Rob Allard
Bungendore War Memorial Committee
C/- 5 Larmer St, Bungendore 2621

16 October 2021

NEW HIGH SCHOOL IN BUNGENDORE APPLICATION NO. SSD-14394209

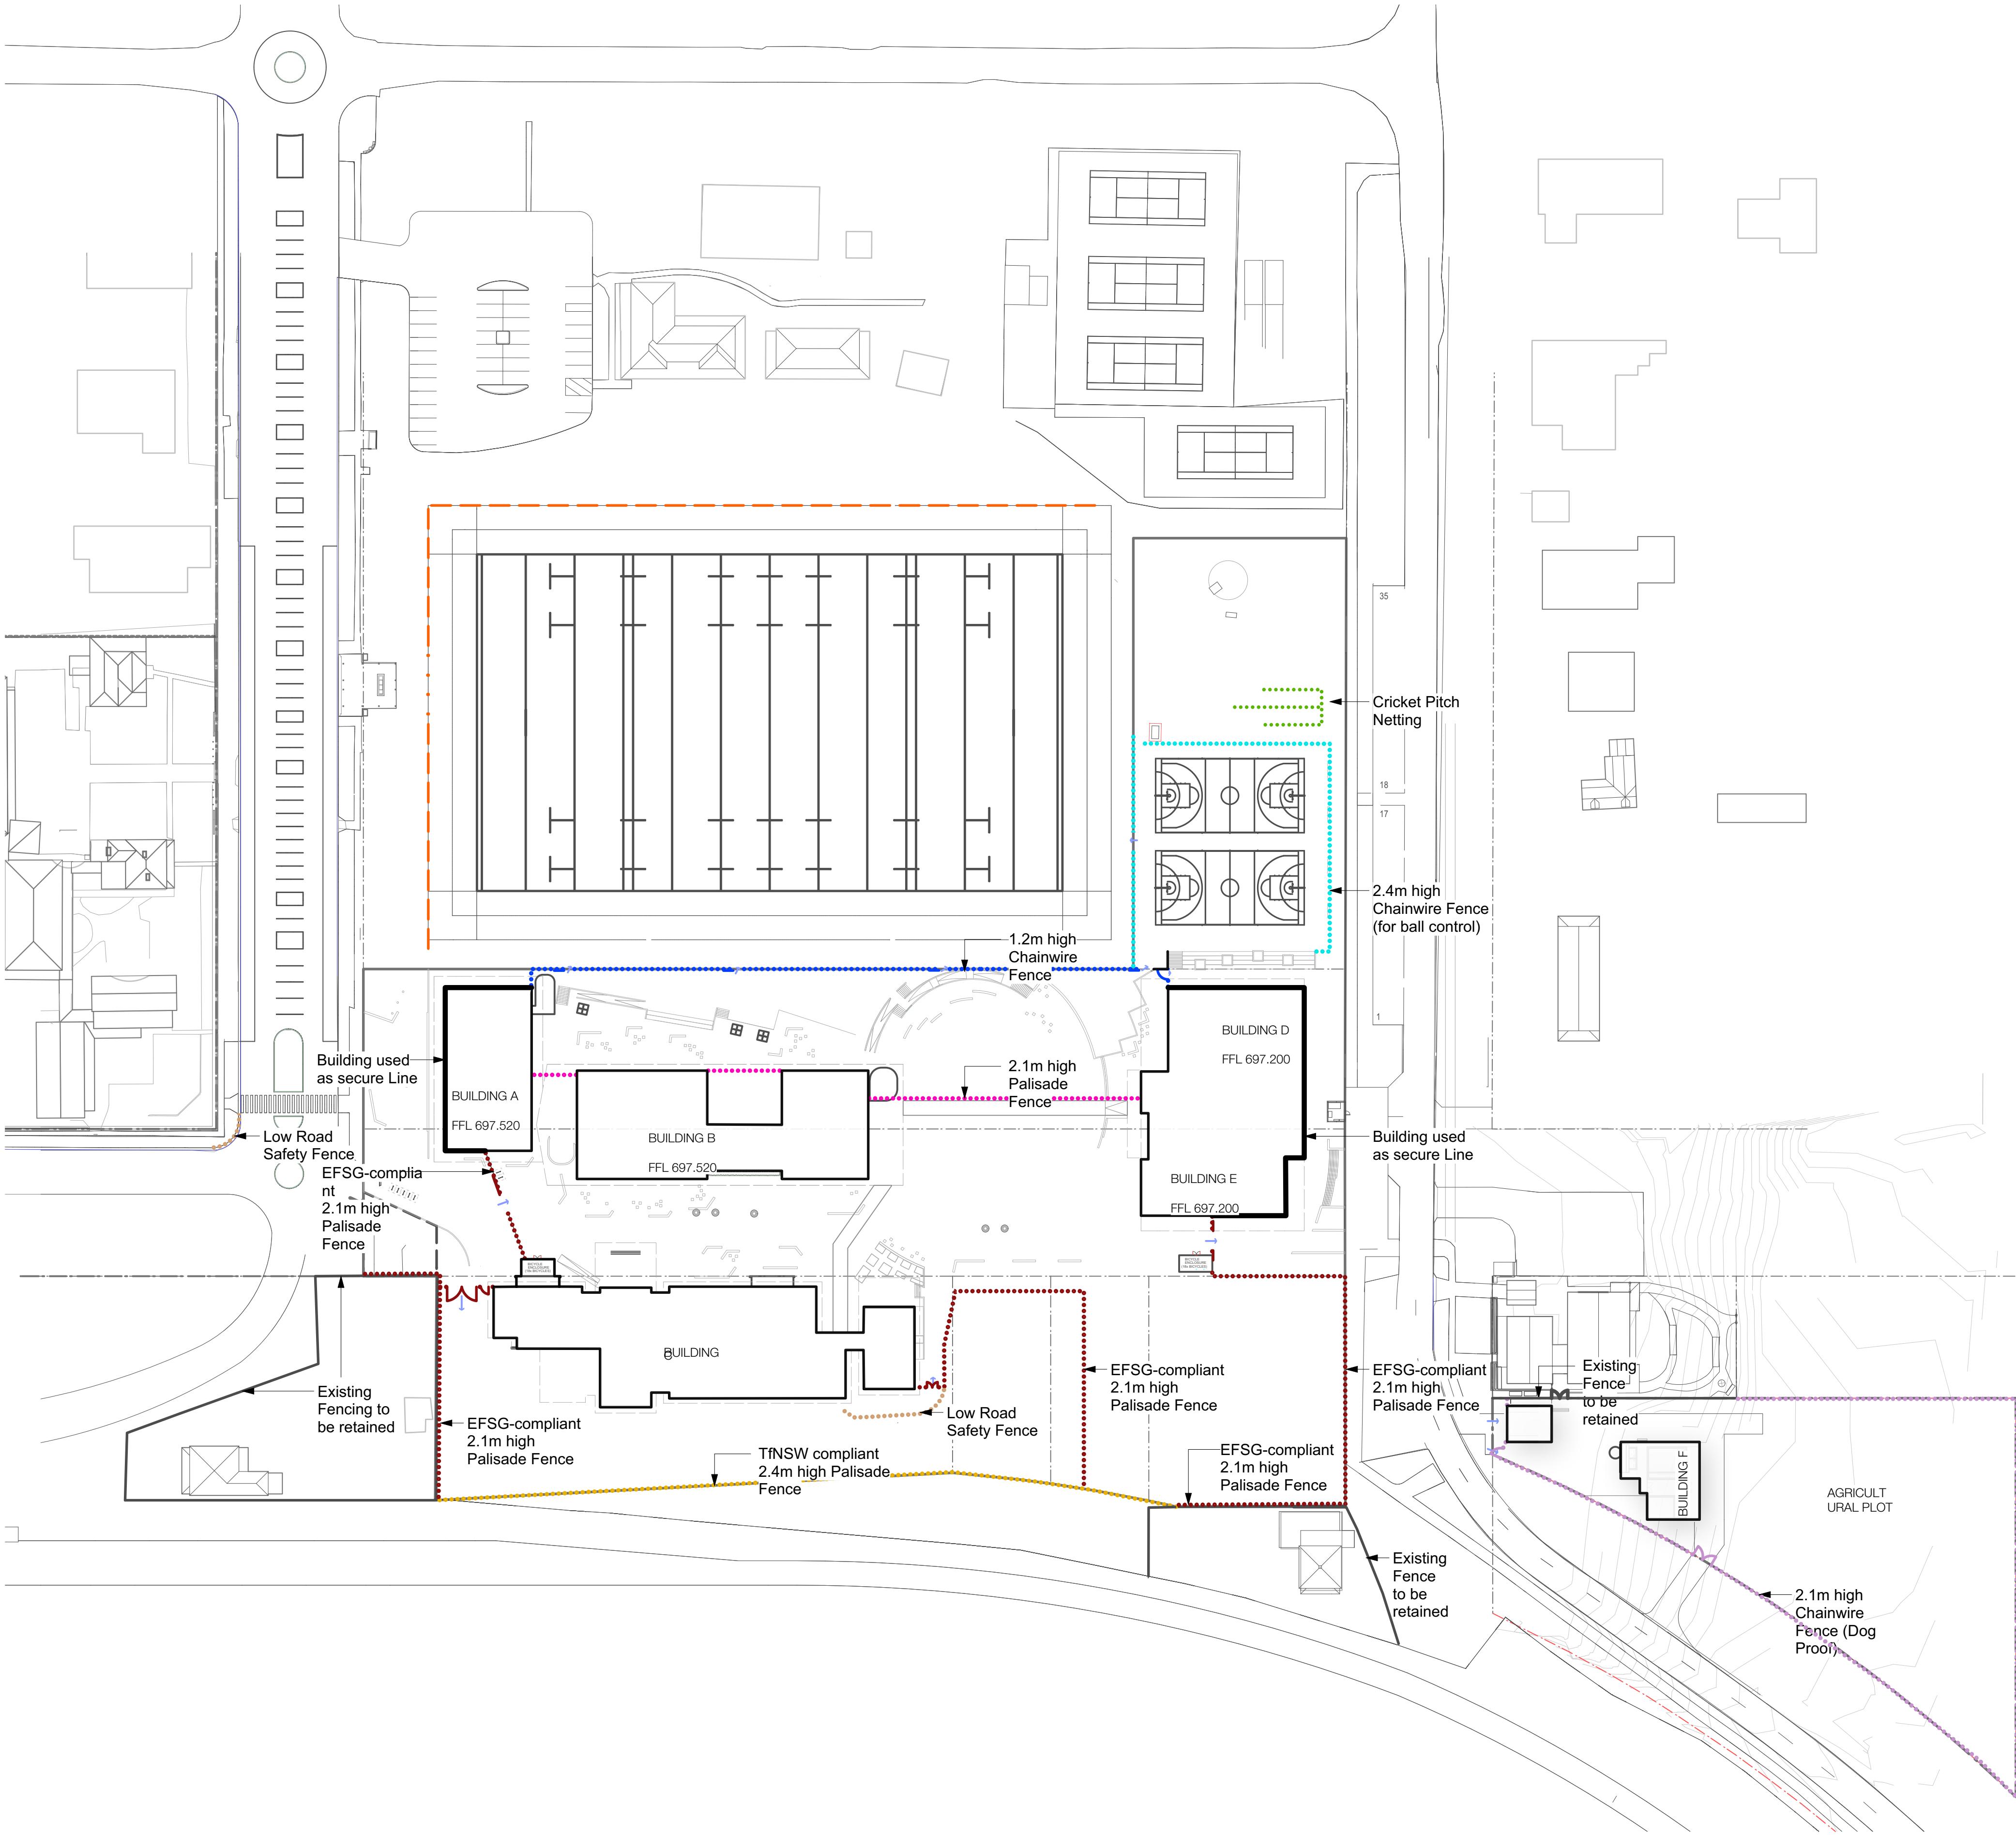
It should be noted that the BWMC has no objection to a High School in Bungendore, but we do strongly object to the proposed fence as indicated in App 4, App 5a, App 5b and App 9.

The location of the fence, as indicated in the drawings, is adjacent to the northern edge of the memorial gardens. During ANZAC Day commemorative services the general public use this area to participate and to witness the service. A fence in this location would not allow the public to easily congregate in this area. It is noted that the fence is an 'intermittent timber post and top rail fence' however with a large crowd assembling such a structure has the possibility of limiting movement of the public in this space and the visual line of the fence would likely be lost therefore presenting the potential for a serious trip hazard. The pictures below show the crowd assembled on the northern side of the memorial in the area where the fence would be located according to the State Significant Development for the school.

Additionally, further on in the 7. Fencing, page 81 it states that the 'new intermittent timber post and top rail fence' will have 'large openings between, and new removable timber bollards adjacent to the soldiers memorial'. The BWMC has reservation on who is expected to remove the 'removable timber bollards' and the quantity. The committee is also concerned about potential safety trip hazards from the removal and storage of these bollards and whether the resultant holes will have safety covers while the bollards have been removed.

App 5a – Landscape Report – D Landscape Design – 12. Fencing Plan page 25 and App 5b – Landscape Drawings – D Landscape Design – 12. Fencing (BHS_LA_SSDDA_2007) indicates these removable bollards but does not give any specifics to height, number etc.
